Consultation Response from KC, Lead Local Flood Authority
2025/93057 Land off, Hermitage Park, Lepton, Huddersfield, HD8 0JU
Discharge of details reserved by conditions 27 (BEMP) , 28 (swale), 29 (surface water) and 30 (storm modelling, flood routeing) of previous permission 2025/90105 for variation of conditions 6 (PROW), 9 (boundary treatment), 38 (bin collection), 40 (car parking) and 41 (access) of previous outline permission 2022/91735 (with access and layout) for erection of 80 dwellings and associated works
Date Responded: 6th July 2026 Responding Officer: Paul Farndale Responding Ref: 4

Condition 29 Drainage Details.

Condition 30 – Flood Routing

ATTENUATION BASIN DETAILS
BASIN 2

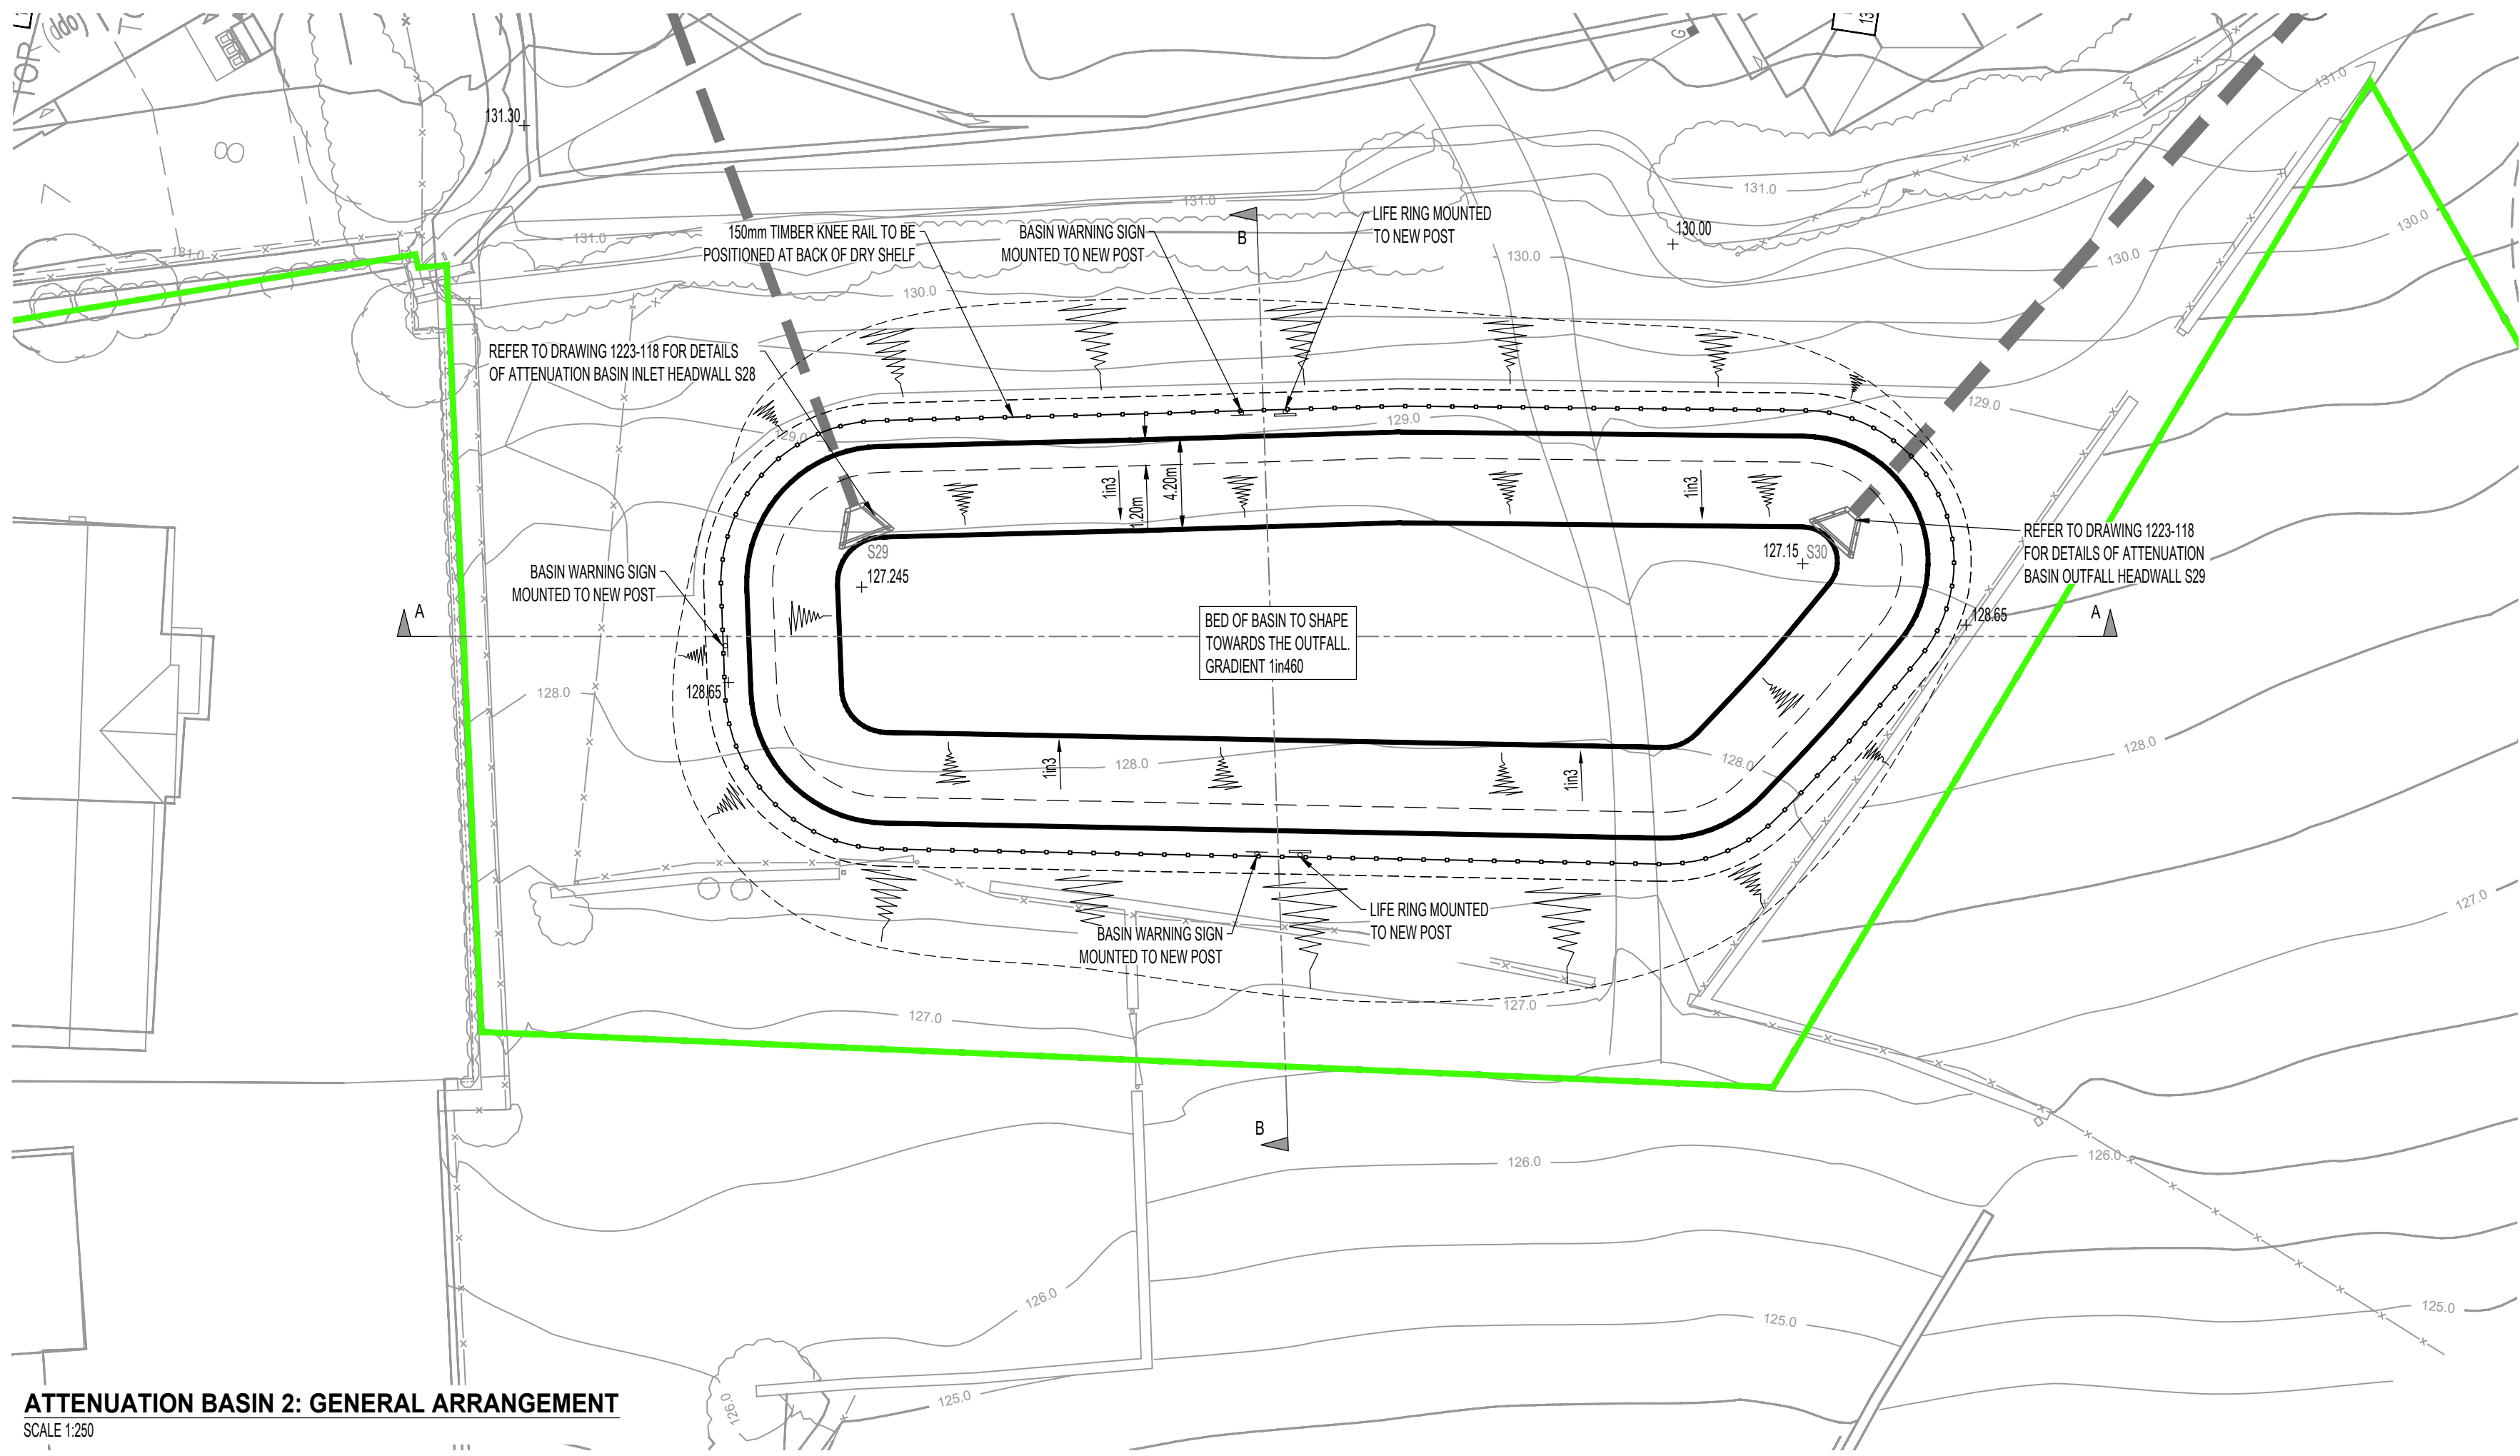
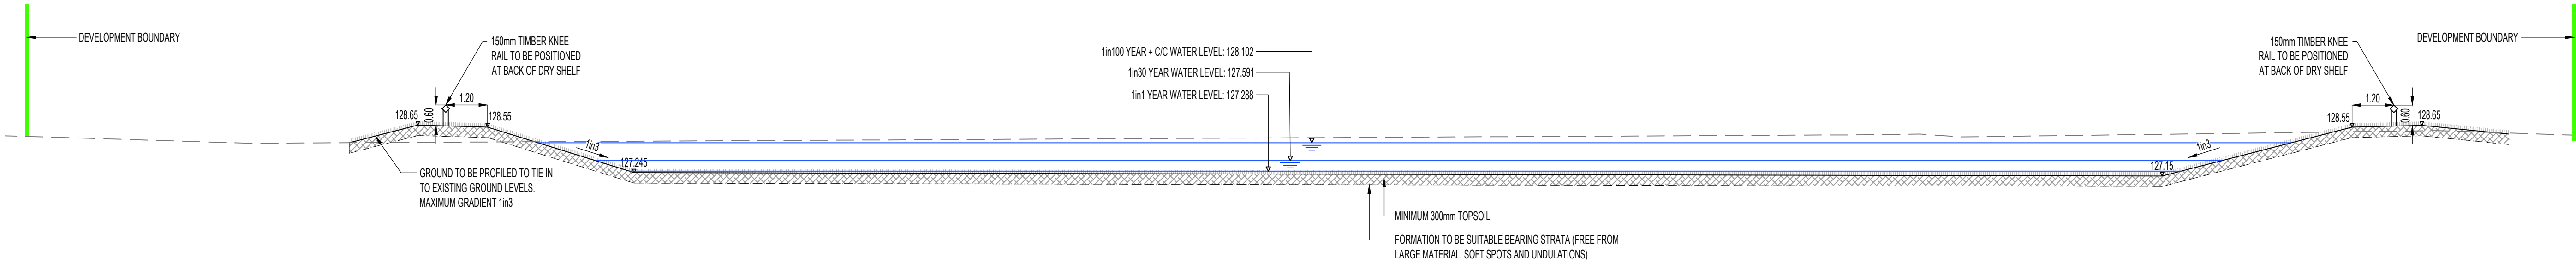
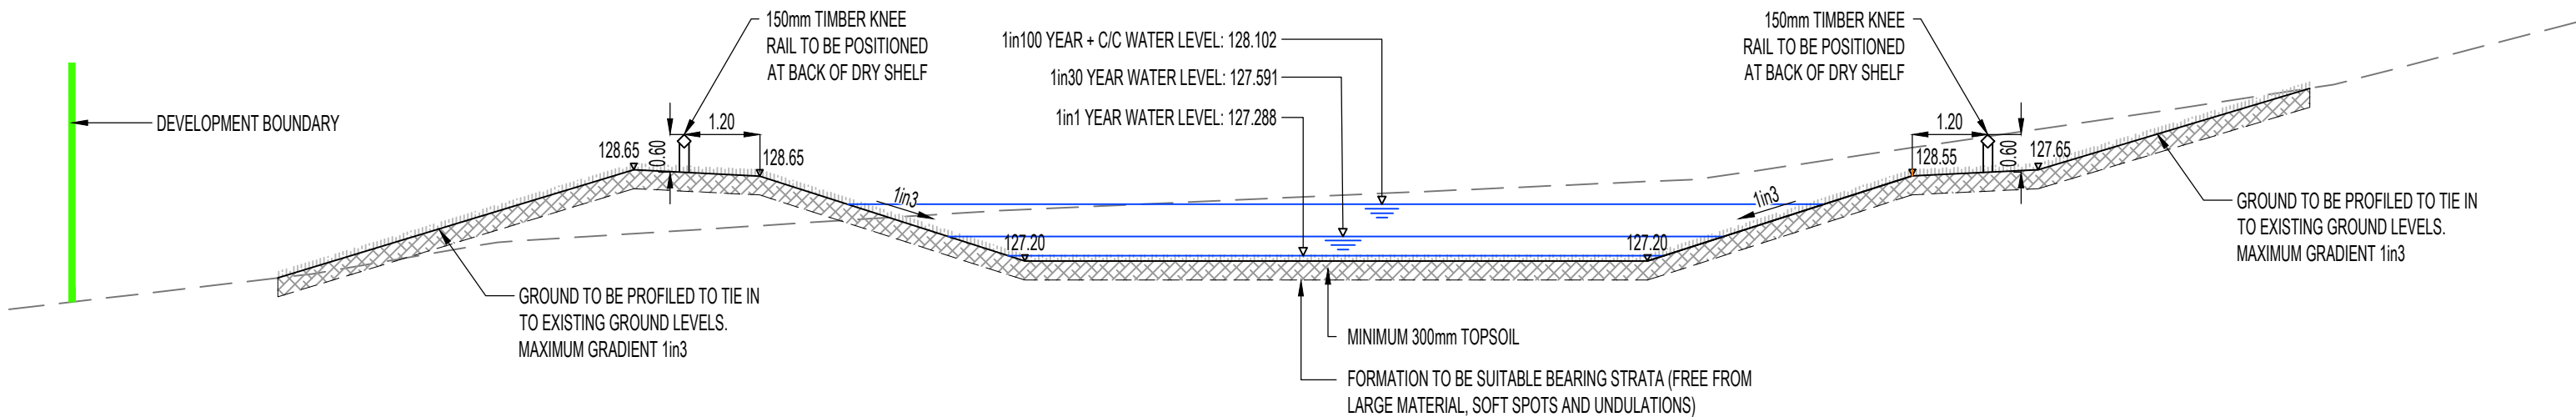
No measurements have been put on the basin drawings. It is appreciated that they are irregular shapes but a maximum width and length for the bottom of the basement and the top (weir point) and any other pertinent measurements are included as previously requested. **Not done.**
